2 Chelsham Road
London

Re: Provision for Vehicle Crossover at 2

PROPOSED
1:50

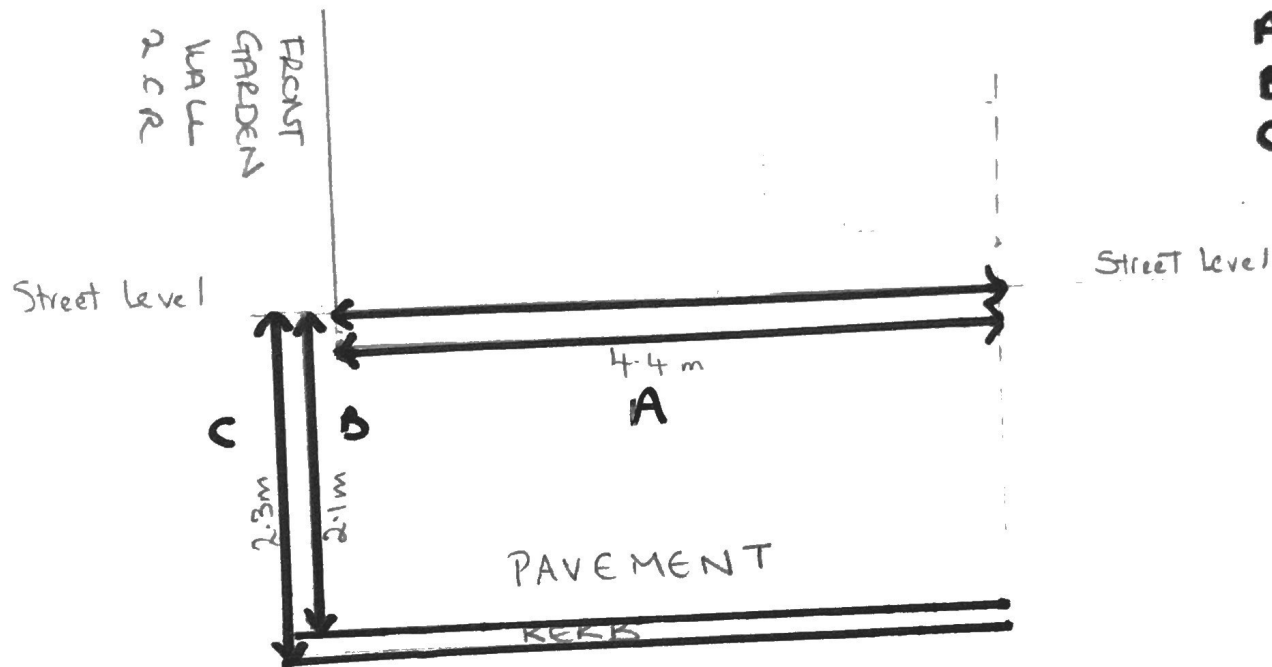
I confirm that the dimensions of your car parking space meet the Council's minimum criteria of 2.4m wide by 4.8m deep which is required to accommodate a vehicle without it encroaching onto the public highway.

Please note that the maximum width permitted for the crossover is 4mtrs. I confirm that the proposed location of the crossover would not adversely impact on highway safety. There are no immediate obstructions to visibility, such as trees, adjoining walls, etc, that would affect highway safety and visibility splays and pedestrian visibility splays that meet the Council's minimum requirements can be provided. Please also refer to the comments provided by the area engineer.

KW/ ITS IS CPZ AREA AND SEE BELOW. KW/ VISITED THE SITE AND MEASURED AND NOTED ENOUGH MEASUREMENT FOR PROPOSED CROSS OVER ON RIGHT SIDE OF THE PROPERTY. (5.3X3) HOWEVER NOTE THE FOLLOWING. THIS ALSO NEED TO REMOVE THE PRIVATE TREE IN PROPOSED CROSS OVER AREA THE PROPERTY .IN MULTIPLE OCCUPATION THEREFORE ITS NEED A FULL PLANNING PERMISSION . THEREFORE OWNER OF THE PROPERTY SHOULD APPLY TO OUR PLANNING DEPARTMENT FOR PLANNING PERMISSION..
